From: Michael Eastham <Michael.Eastham@arun.gov.uk>
Sent: 05 November 2019 13:30
To: Planning.Responses <Planning.Responses@arun.gov.uk>
Subject: FW: EG/22/19/OUT - Boweries, Barnham

Review of Stage 1 Safety Audit and Designers Response.

**DOMUSEA DEVELOPMENTS PROPOSED RESIDENTIAL DEVELOPMENT
THE BOWERIES, BARNHAM ROAD, EASTERGATE
STAGE 1 - ROAD SAFETY AUDIT
OCTOBER 2019**

Review of stage 1 safety audit carried out by Martyn Parr, Mayer Brown during October 2019, and designer's response.

scale 1:250 @ A3 date OCTOBER 2019 drawing number MBSK191001-01	title VISIBILITY SPLAYS AT ACCESS	client DOMUSEA DEVELOPMENTS project THE BOWERIES, BARNHAM ROAD EASTERGATE	drawn by JME checked by AP cad file FIGURES A.DWG rev. D
---	-----------------------------------	---	---

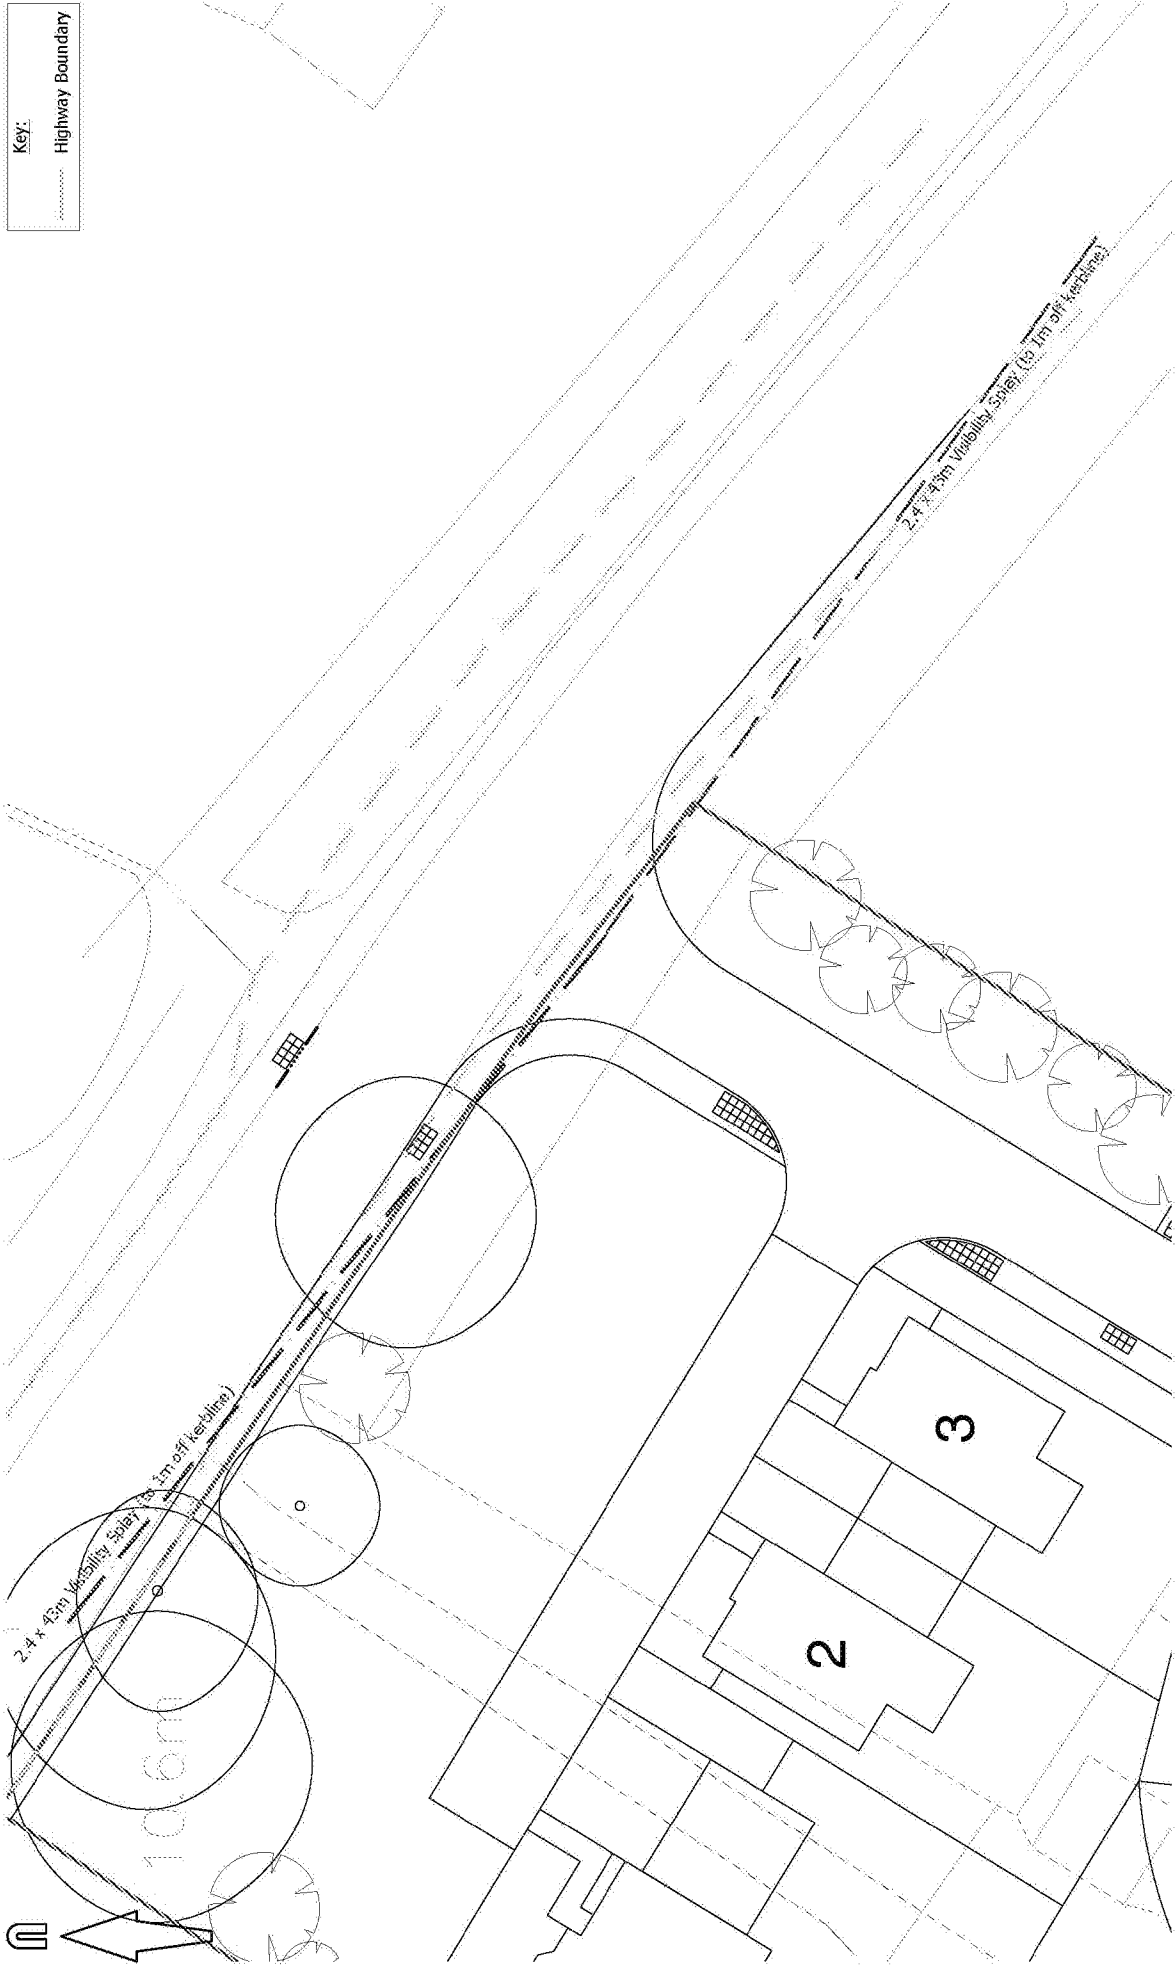
Location: Site Access

Summary: Obstruction to visibility splays

Agree with auditor, this matter can be addressed by way of planning condition.
